# CITY OF ALBUQUERQUE

March 31, 2011

**Re: Project Hal (Molina Healthcare), 2610 Turning Dr. SE,  
Request for Permanent C.O. - Approved  
Engineer's Stamp dated: 4-14-10 (R-16/DA2002)  
Certification dated: 03-28-11**

JOB NO.:
DRAWN BY: MJB
ISSUE DATE: 02/16/10
REVISIONS: 04-14-2010
SHEET NUMBER: C100

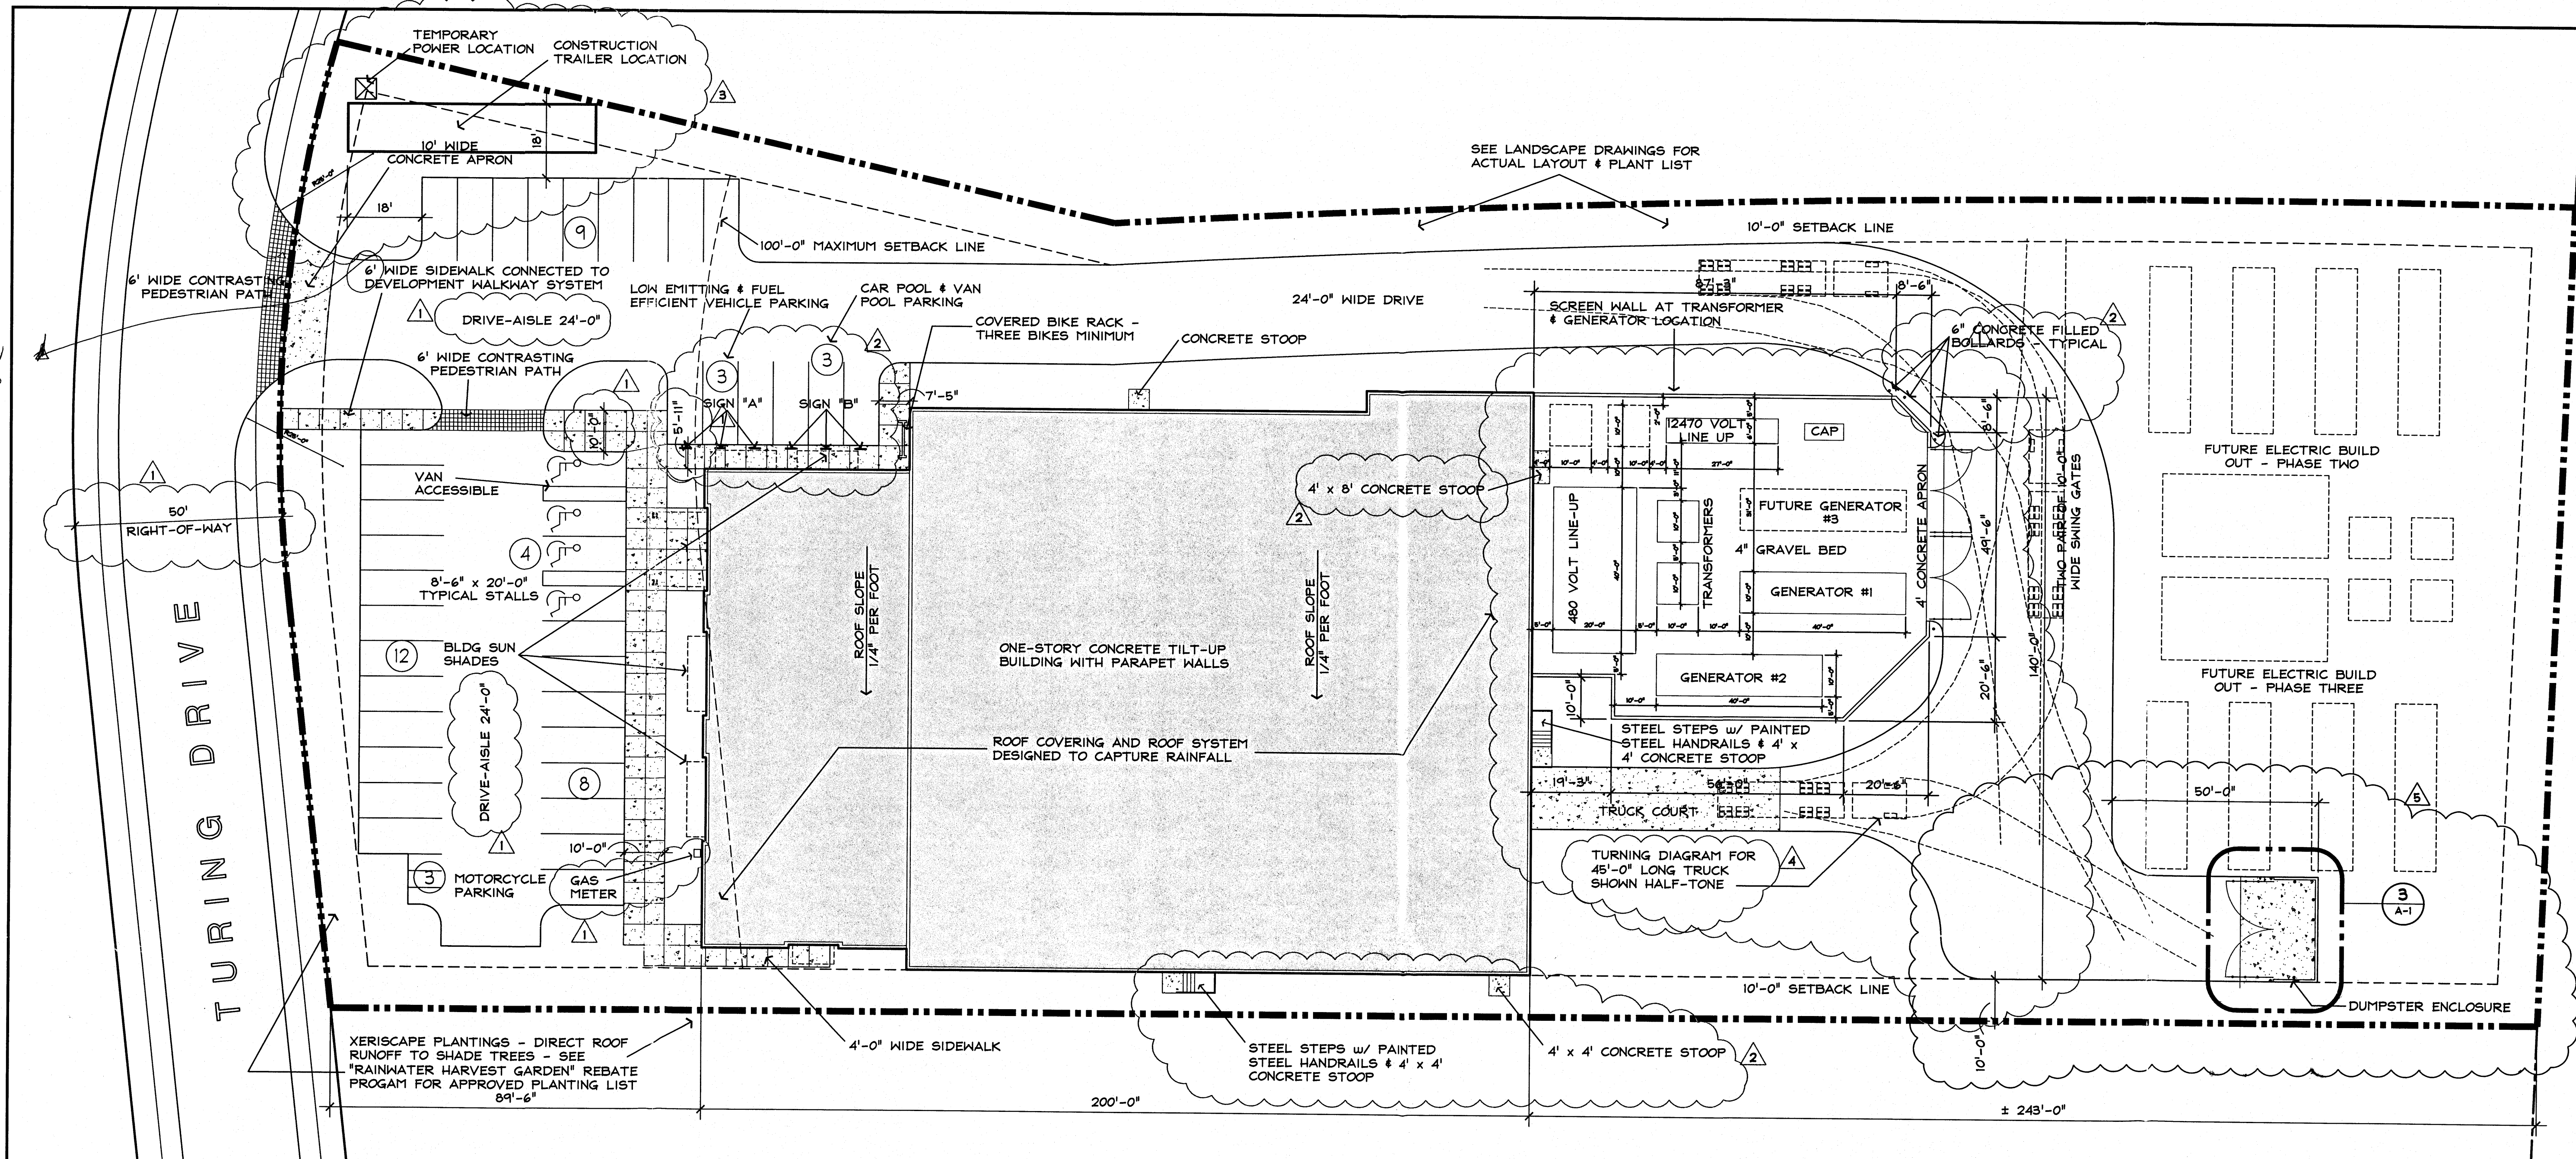
- This plan proposes grades on the GSA site to the north that are in conflict with the approved Grading Plan for that site stamp date 2-2-10. The GSA site has proposed a LEED pond with an inlet at 5296.5 in the vicinity of a proposed 5300 grade on this plan.
- The GSA Grading Plan ties to existing grades in the OS Tract, whereas this plan proposes new grades in the OS Tract.
- Proposing to cut this site and the OS Tract to 5294 will create a 4 foot grade difference between this site and the site to the north.
- Why was an elevation of 5293 selected for the Top of Pond elevation, when the existing contour is 5300? Can the Top of Pond elevation be 5296? Would a Top of Pond elevation of 5296 be beneficial in reducing stockpiles at Mesa del Sol?

- The grading tieback on the GSA site to the north has been removed. We now tie back to existing grades along the Molina northern property line.
- Based on the approved Mesa del Sol Drainage Area 2 Drainage Management Plan (dated 11-4-08); the top of pond for Drainage Area 2 (DA2) was designed as 5,293. We are tying back to this top of pond elevation along our western property line.
- During the construction of the regional retention pond, Mesa del Sol will not have an opportunity to grade on the Molina property so the grades along the western property reflect future full build out of the pond.
- The elevation of the top of pond for the Regional Retention Pond for DA2 was set based on the surrounding roadway grades and earthwork considerations. It would not be feasible to adjust the top of pond elevation based on the amount of infrastructure that is currently in place.
